SHEPHERDS BAY URBAN RENEWAL, MEADOWBANK

STAGE 1 PROJECT APPLICATION (MP 09_0219)

Response to Additional Information Request Preferred Project Report

RESPONSES TO ADDITIONAL INFORMATION REQUEST

Building Name : STAGE 1 PROJECT APPLICATION (MP 09_0219)
Drawing Title : BELMORE STREET ELEVATION

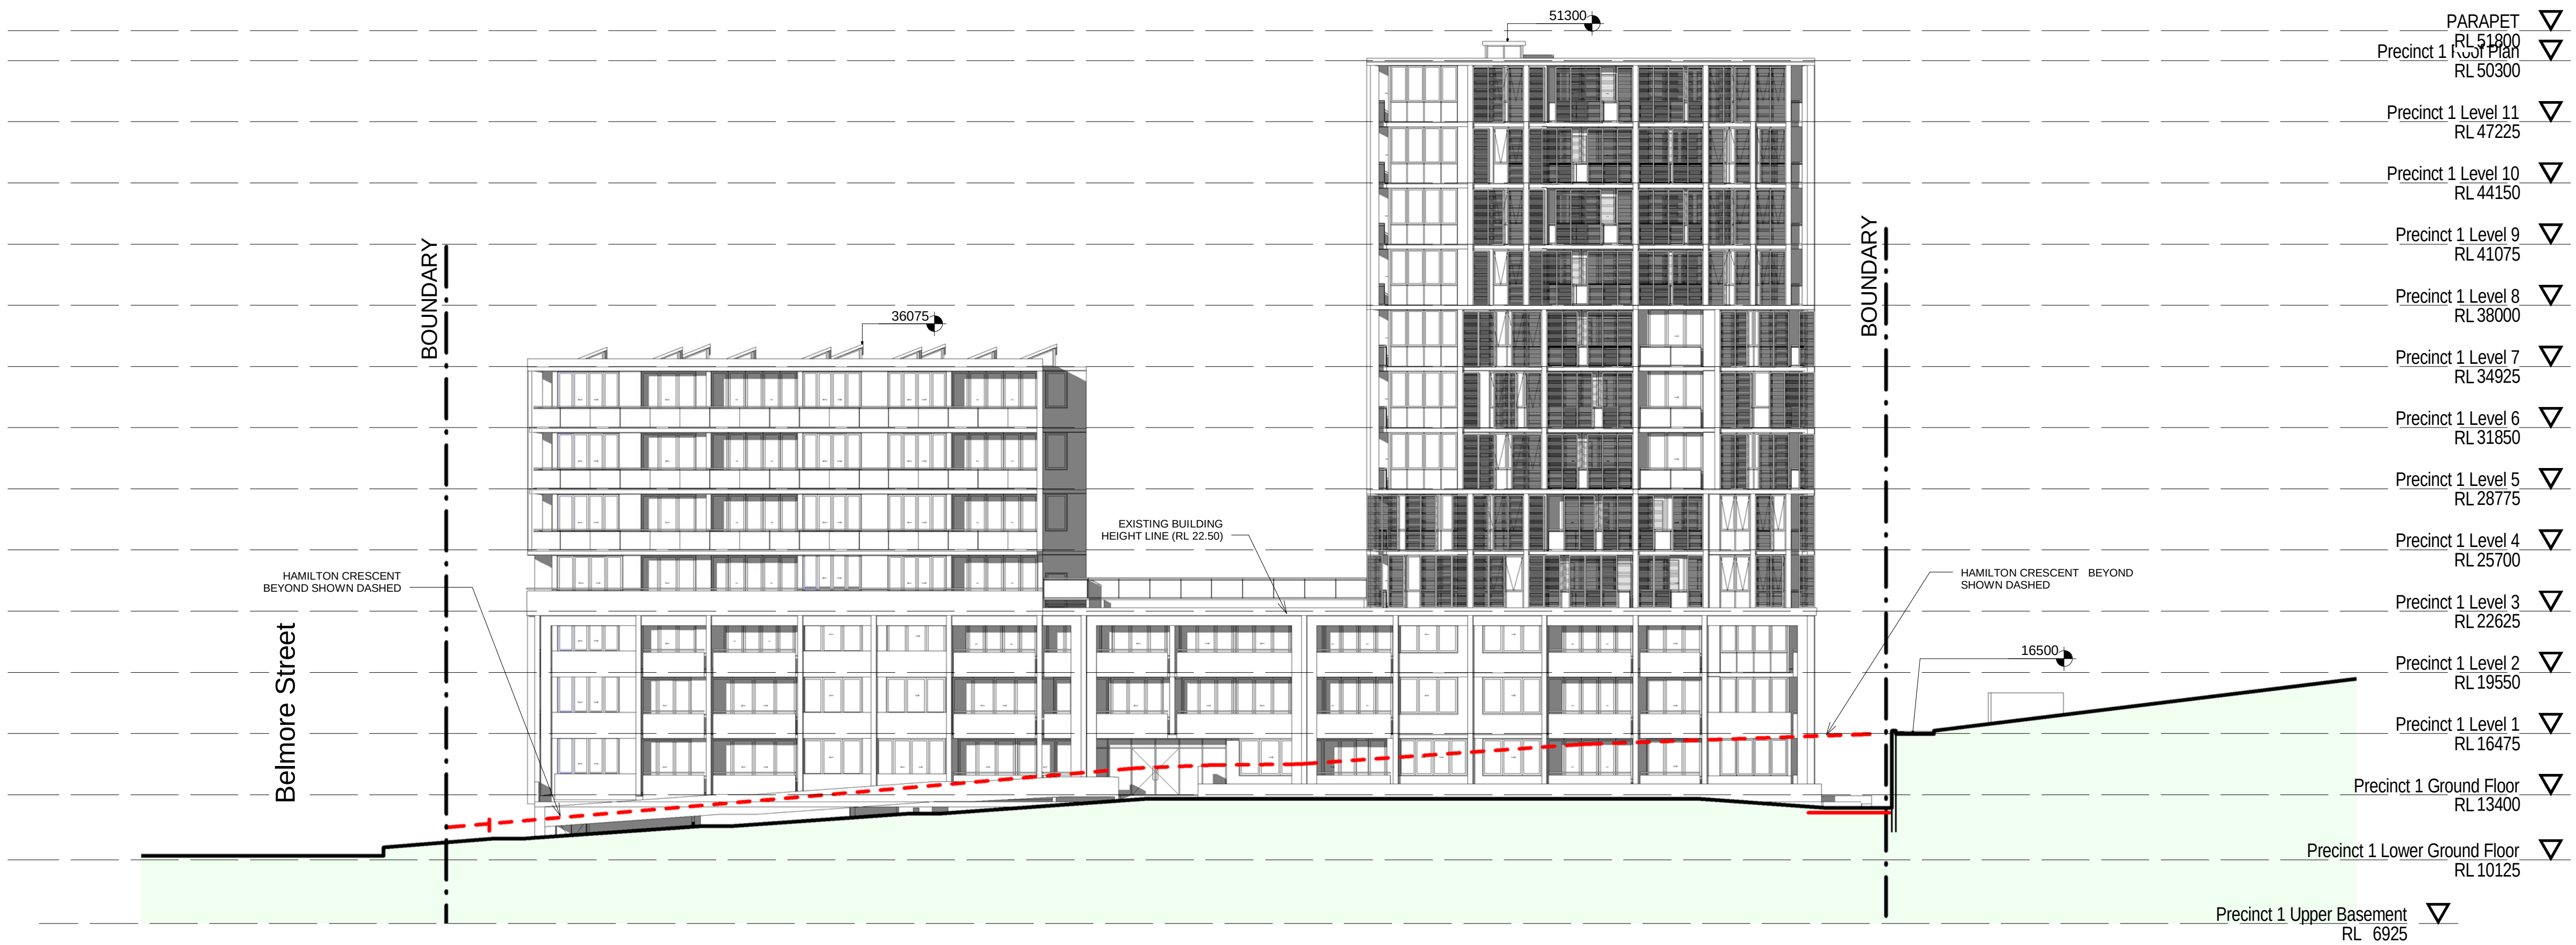
4.	Justification for the height of the basement exceeding above 1.2 metres in Rothesay Street and Belmore Street, noting that it is considered a storey in this location. Further the lower level at the Hamilton Crescent frontage will be subterranean which is not supported. An alternate design should be considered which may include an alternate basement configuration with the use of ramps to provide for level changes within the basement.	Additional apartments at the basement level fronting Rothesay Avenue and Belmore Street have been provided to address the additional storey. Detail sections with landscape provided of the ground floor corner fronting Hamilton Crescent.	See Architectural Drawings - A 101-7 See Architectural Drawings - A 101-7

1 Section A-A1
A 122/4 1 : 200

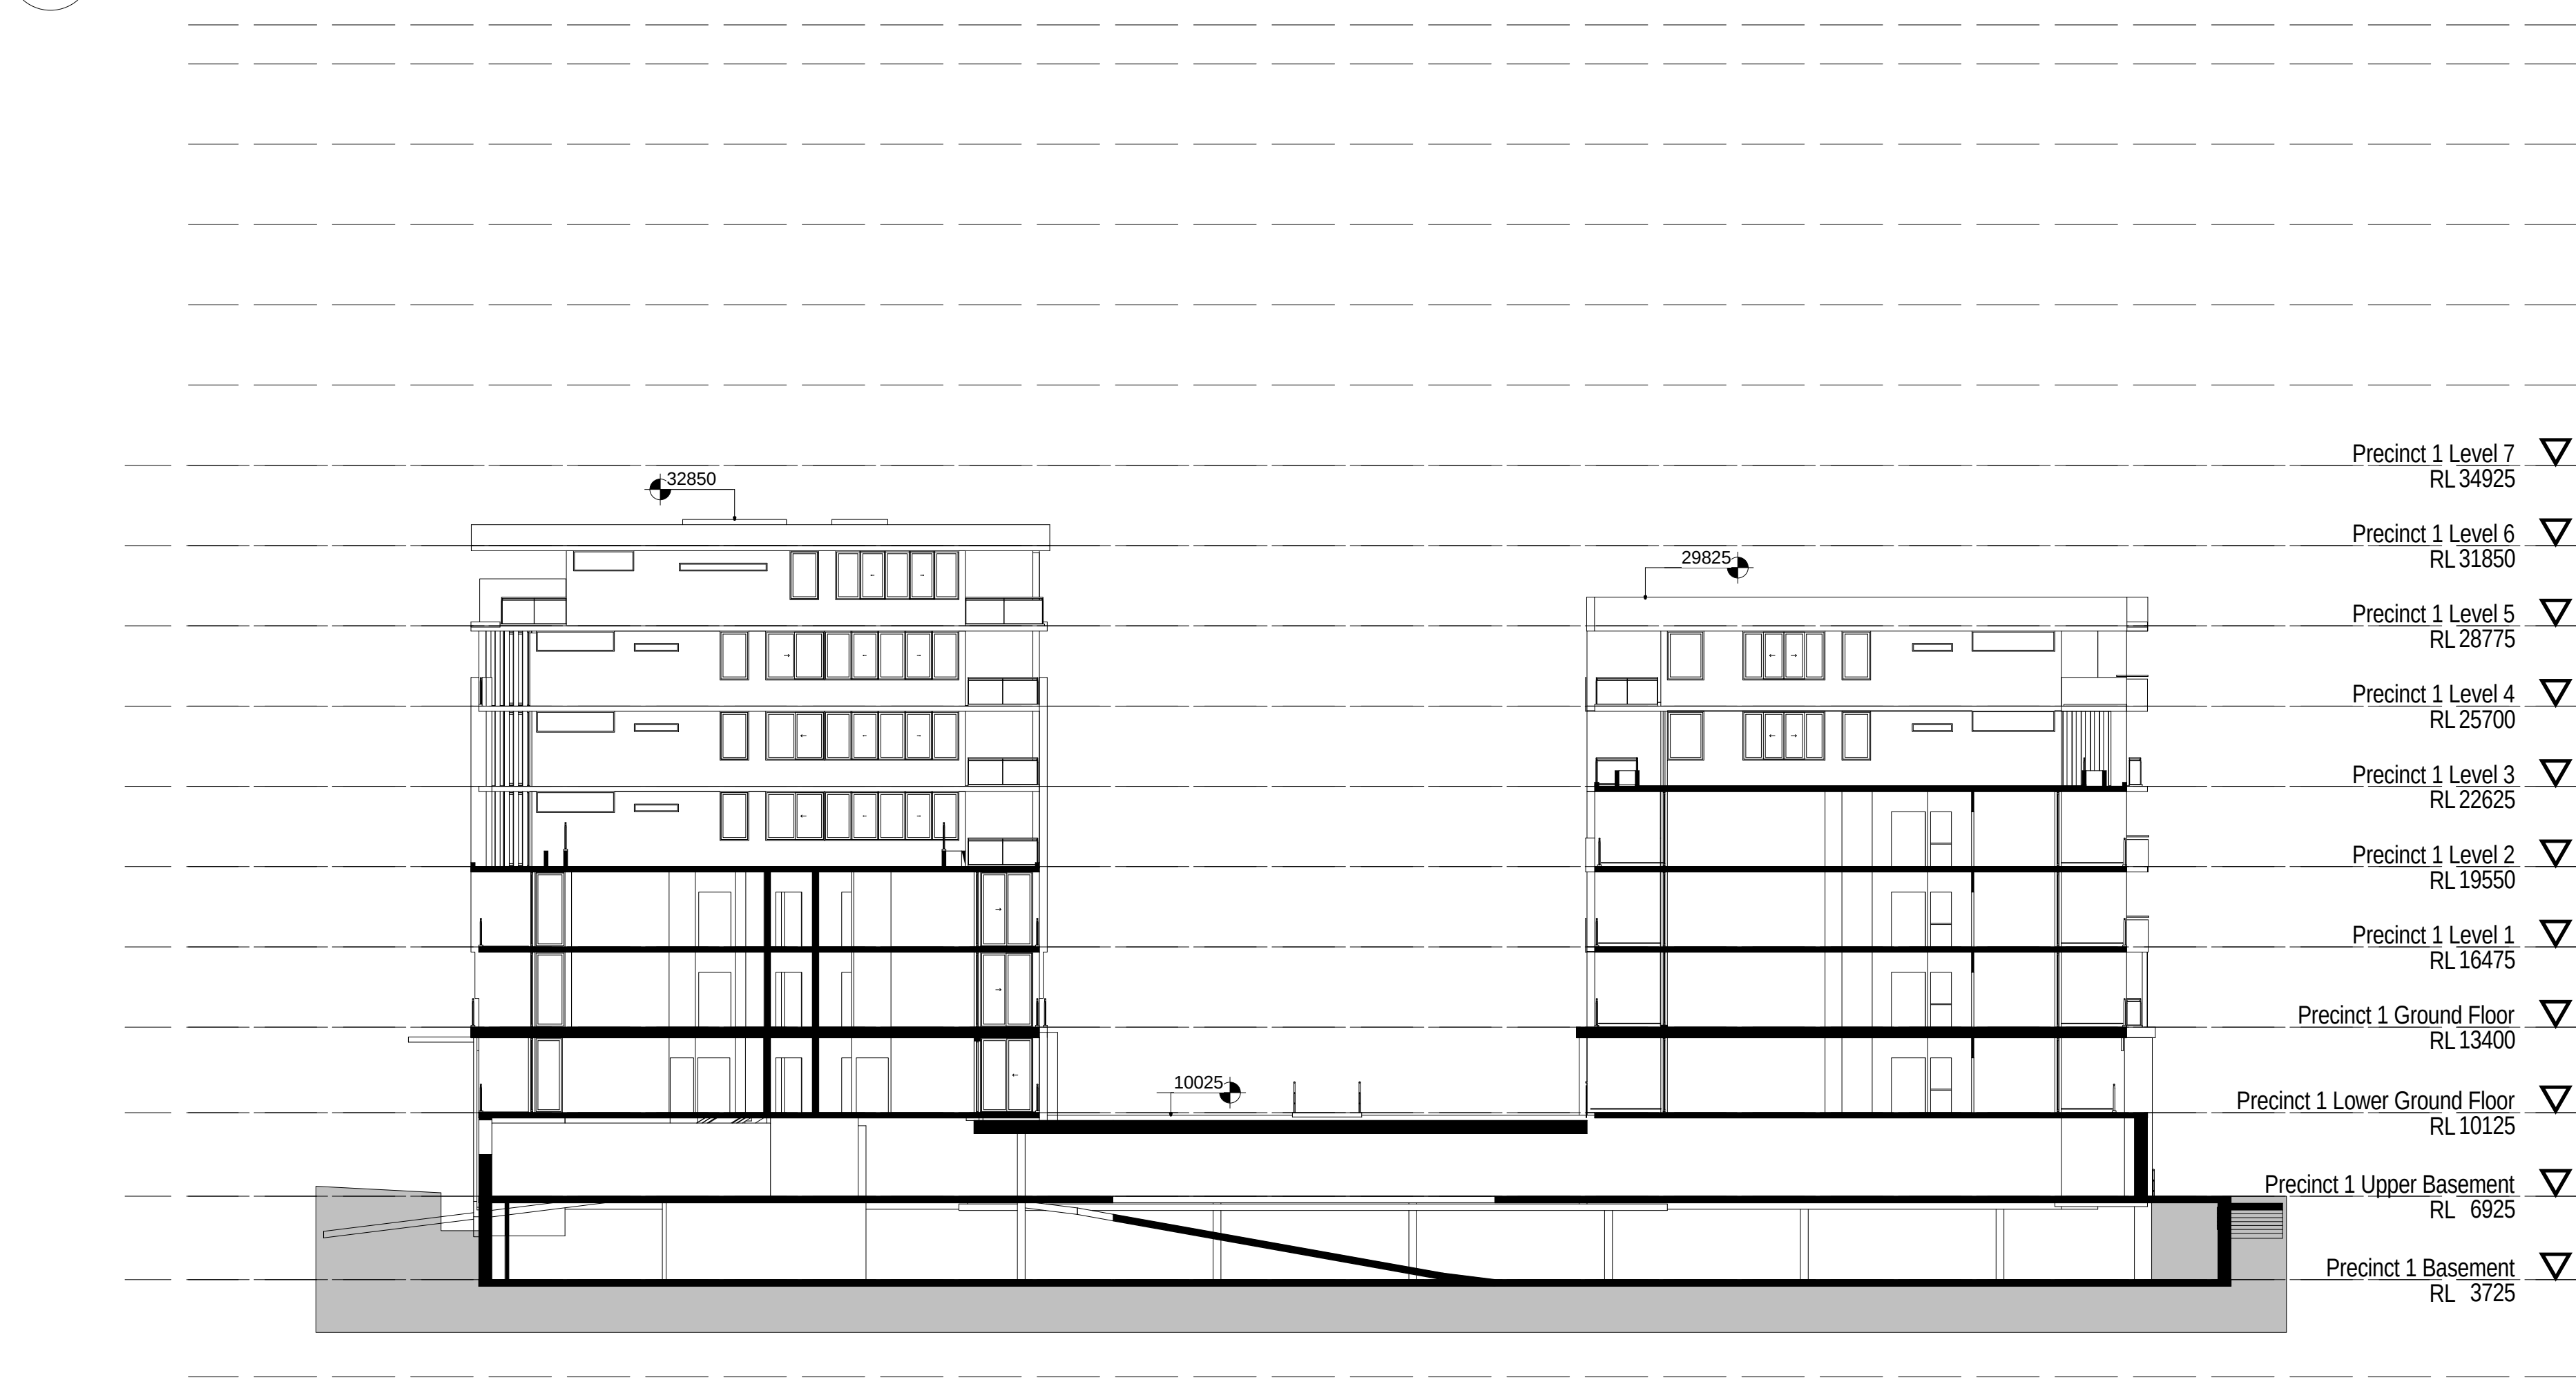
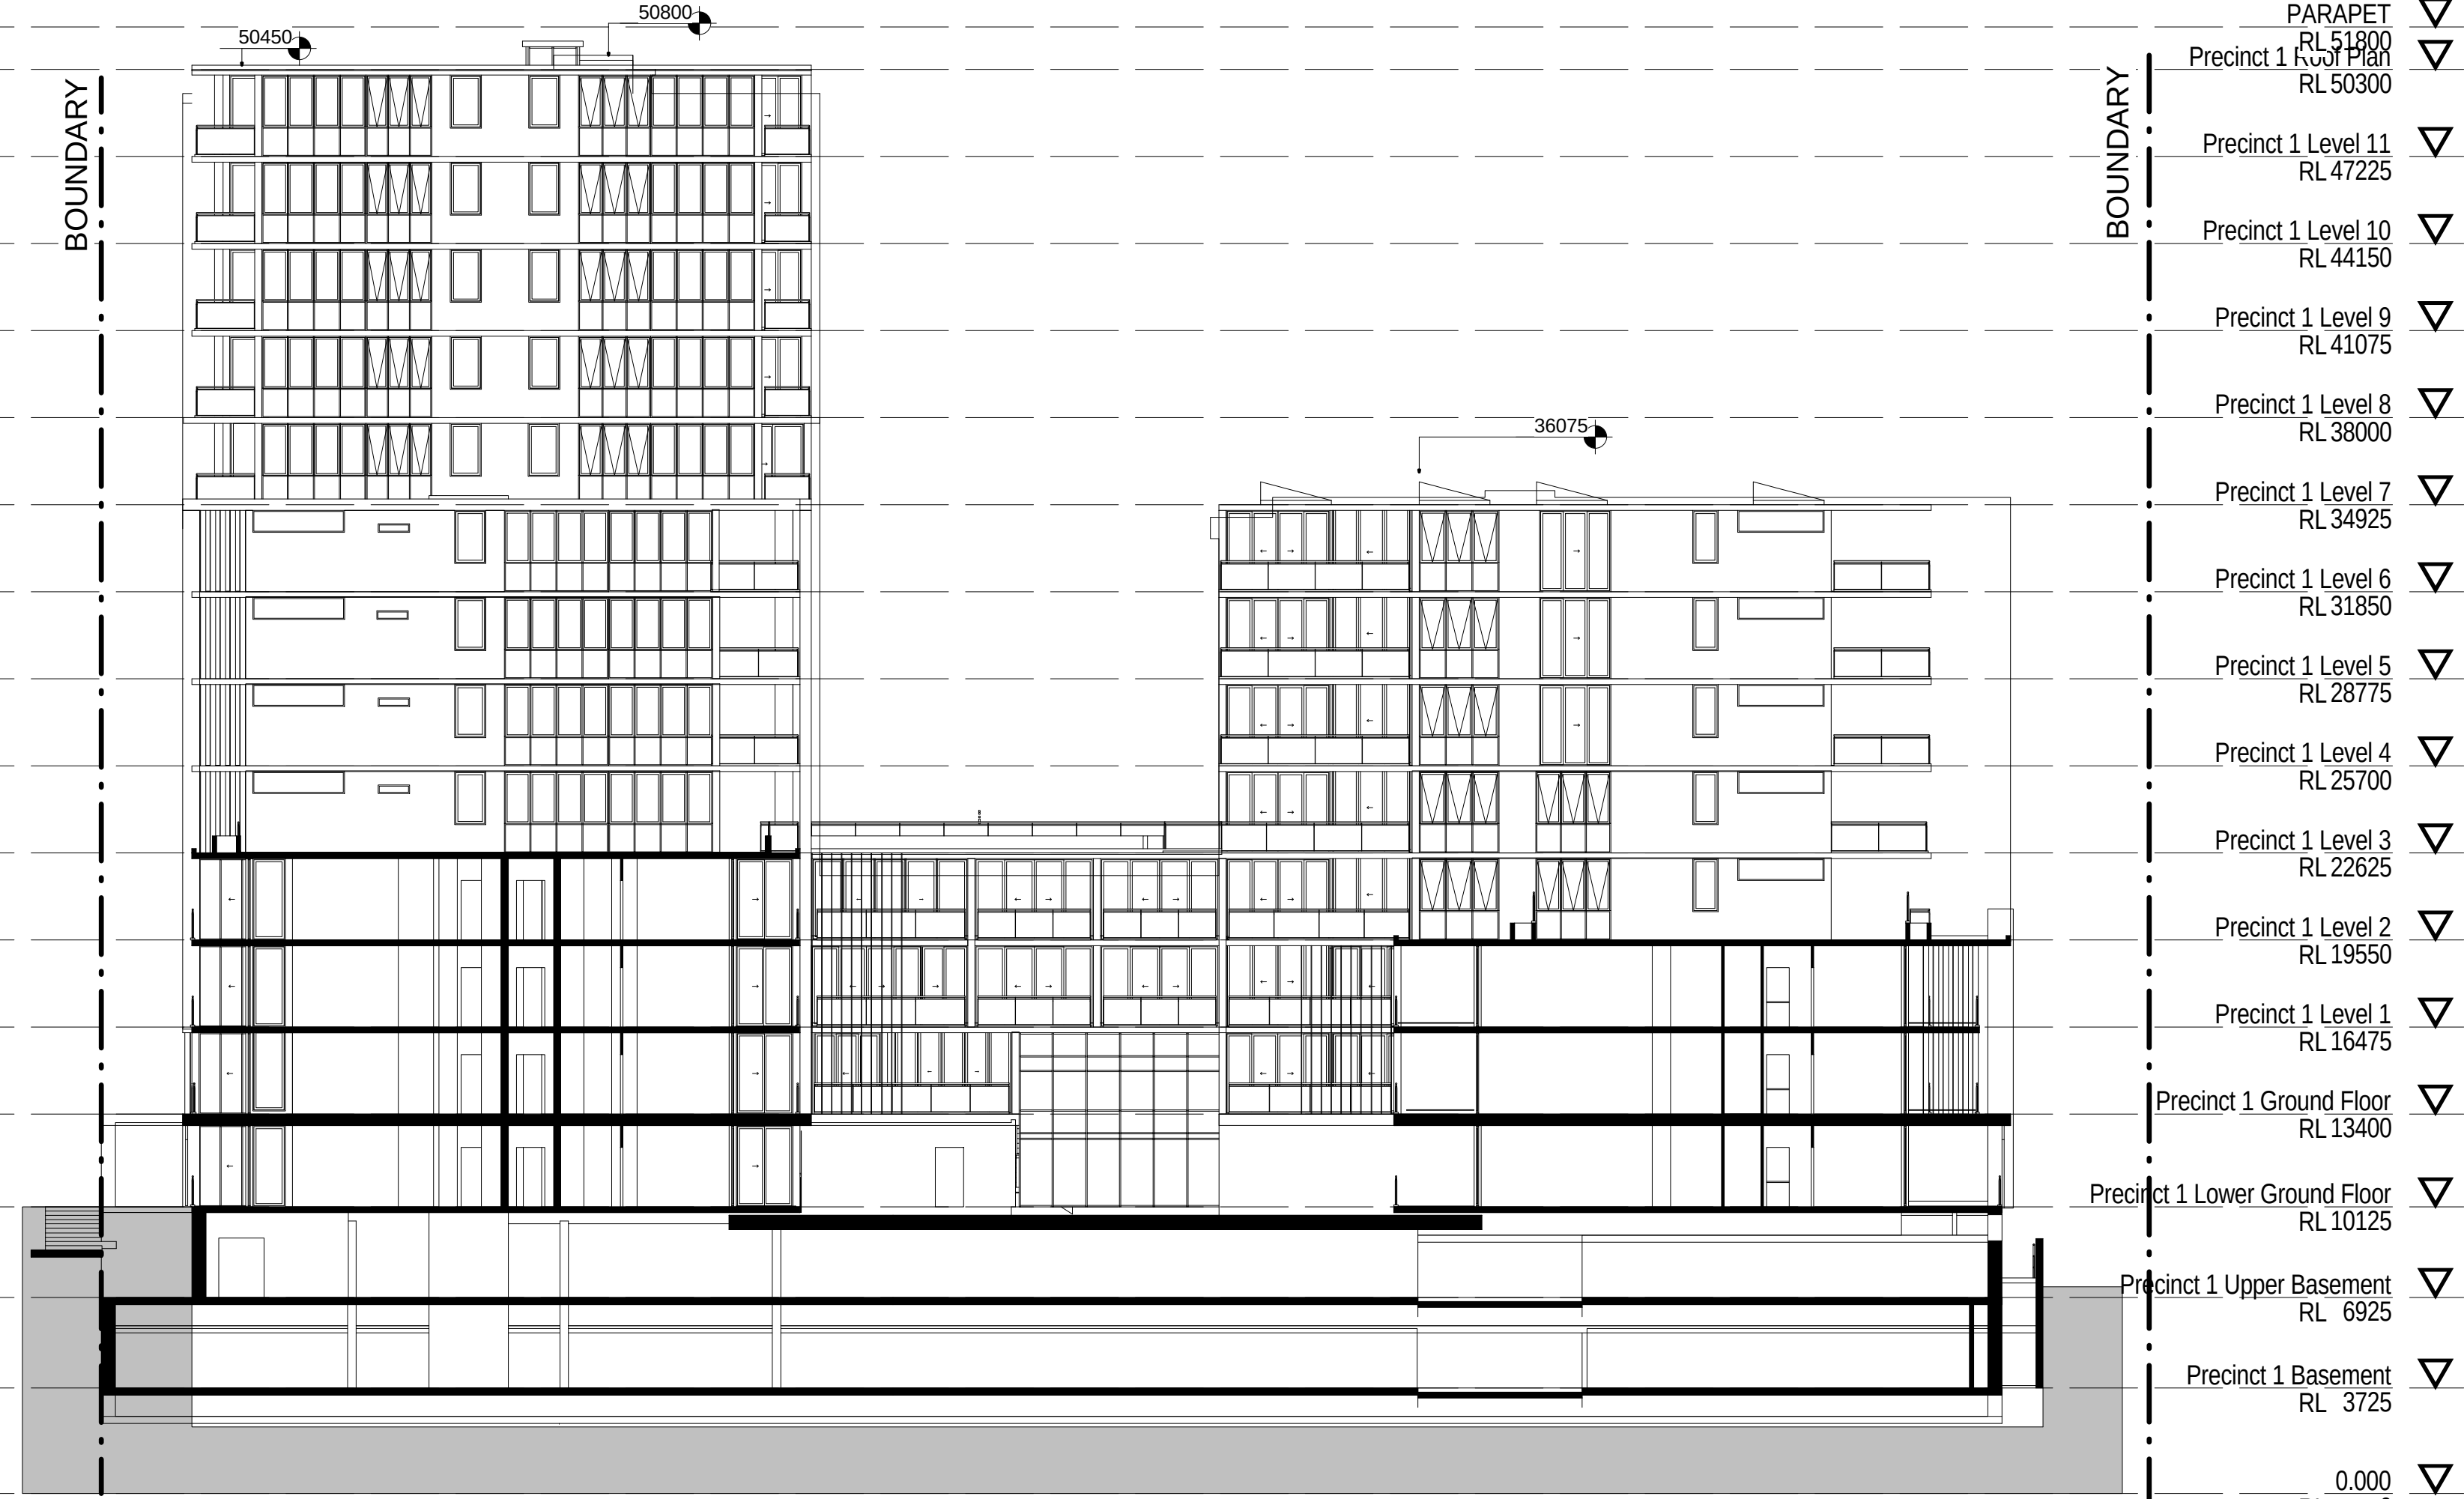
11.	Measures to provide privacy to the balconies of Unit 1-12 and 1-17, 1-21 and 1-25 and 2-12 and 2-17.	Privacy screening to the balconies of Unit 1-12 and 1-17, 1-21 and 1-25 and 2-12 and 2-17 is now included on plans and elevations.	See Architectural Drawings - A105-5, A 106-5, and A 122-4 at Annexure 1
